V1_Grading & Erosion Control (GEC) Plan_COMMENTS.pdf Markup Summary

Glenn Reese - EPC Stormwater (5)

MONUMENT ACADEMY

PHASE 2
CONSTRUCTION DOCUMENTS

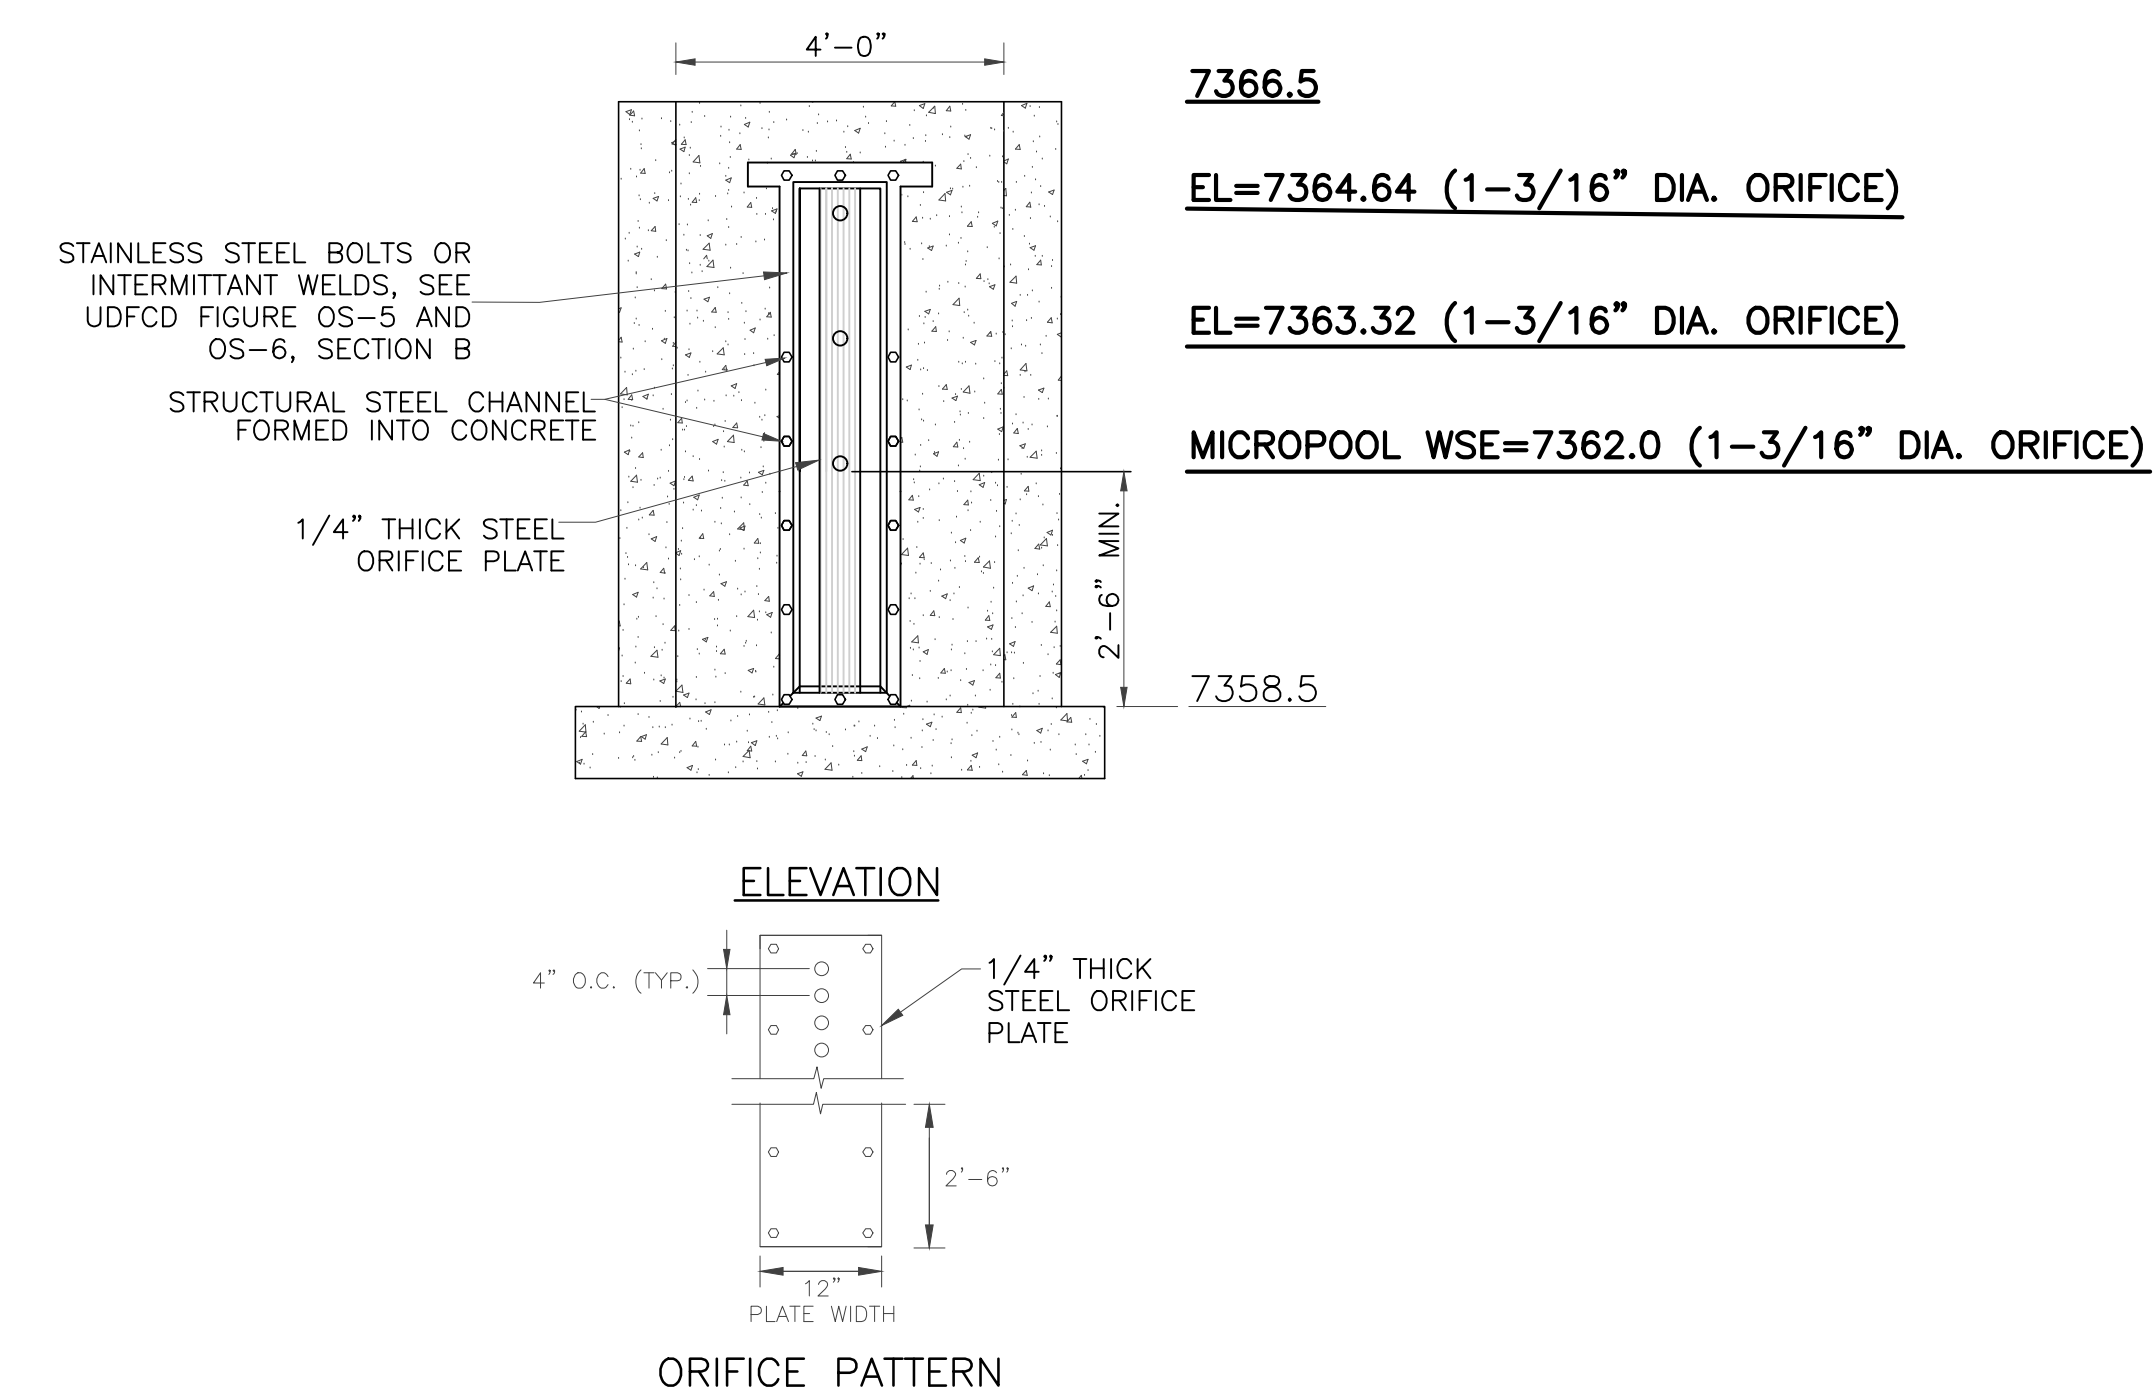
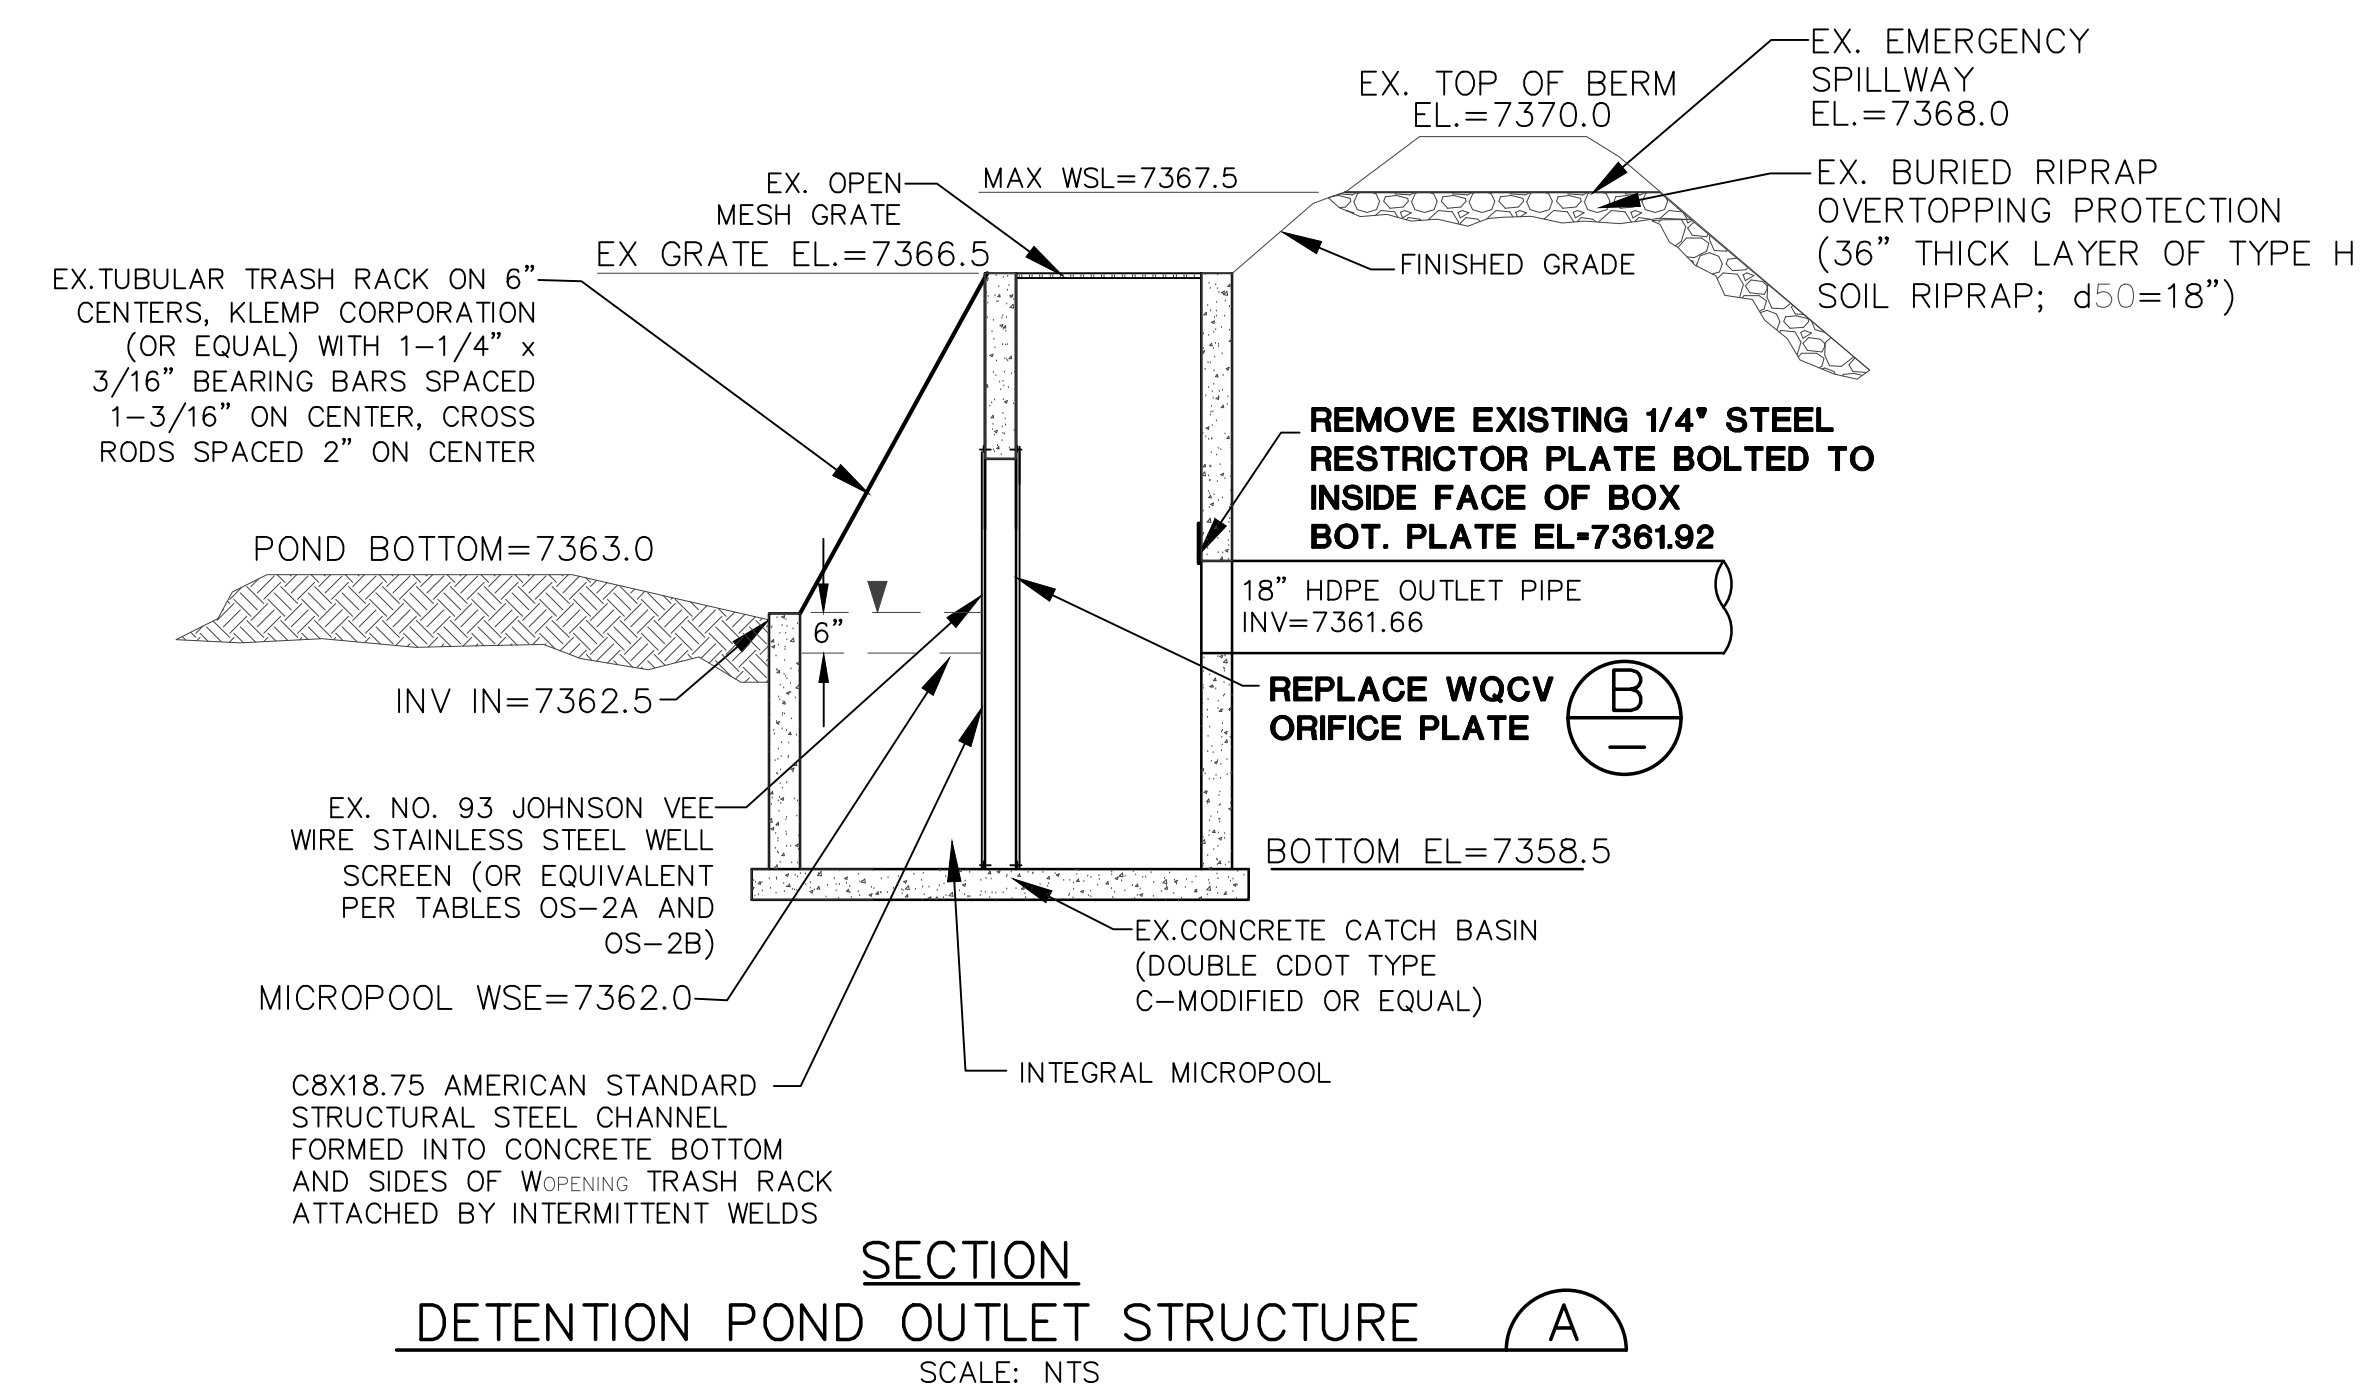
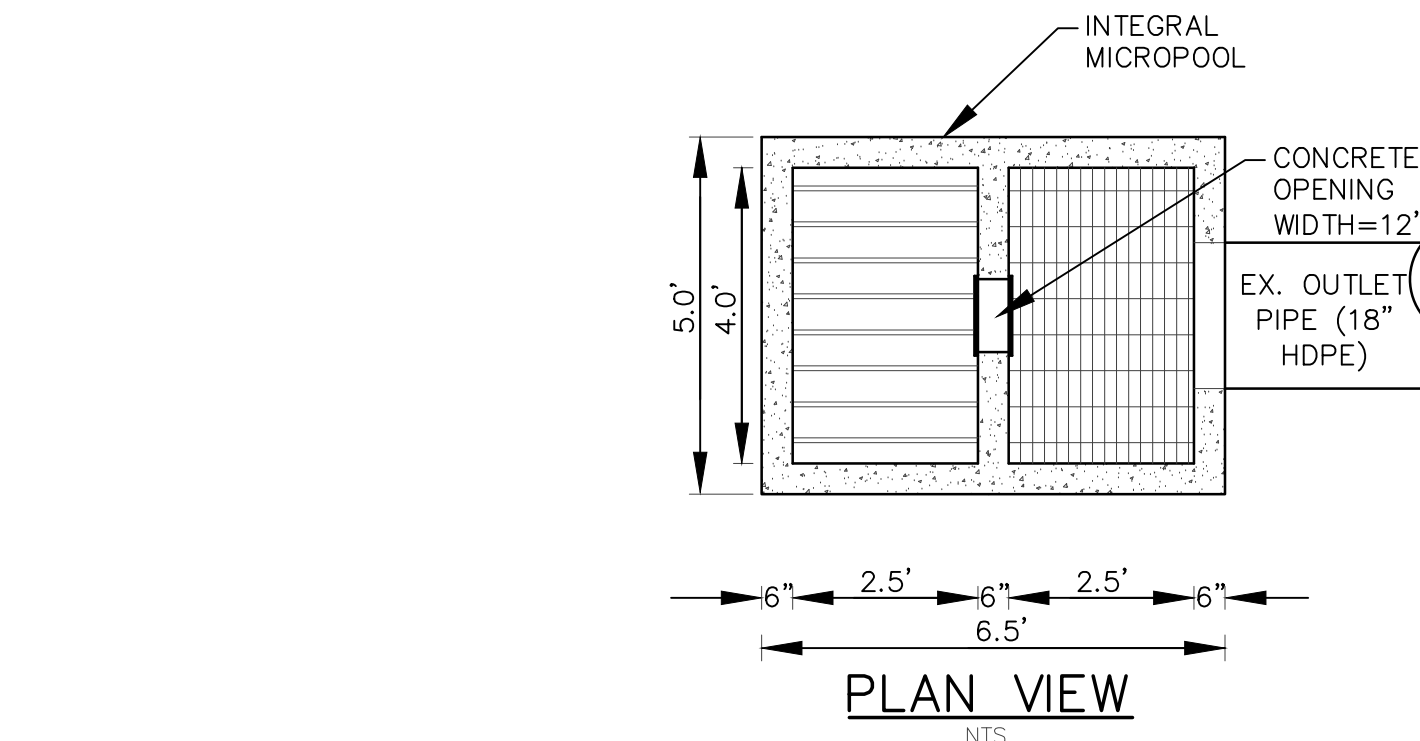
Gasket: Provide more detailed gasket info like thickness, width, brand/model, etc.

This existing low point allowed runoff to collect and be conveyed down into the pond via a pipe and ended in a riprap apron. By removing that low point and pipe, all of the upstream flows will enter the pond by spilling down the embankment.

Can you look into how much flow will enter the pond from this south side? From my rough takeoff, it appears to be about 3ac. Meaning this is a concentrated inflow point so some kind of controlled inflow is in order (riprap rundown, pipe + forebay, etc).

Based on input gathered from industry experts, below is the recommended gasket spec:

The gasket shall be made of 1/4-inch thick, 60 durometer EPDM rubber in a continuous sheet the size of the orifice plate. The sheet shall be placed between the orifice plate and the concrete wall, with the width of the overlap between the plate and the concrete. Openings shall be cut into the sheet corresponding to the plate bolt holes and the concrete wall opening, cuts made either by the contractor in the field or by the manufacturer. Or equivalent gasket approved by EPC. Note that caulk is not an approved equivalent and will not be accepted by EPC.
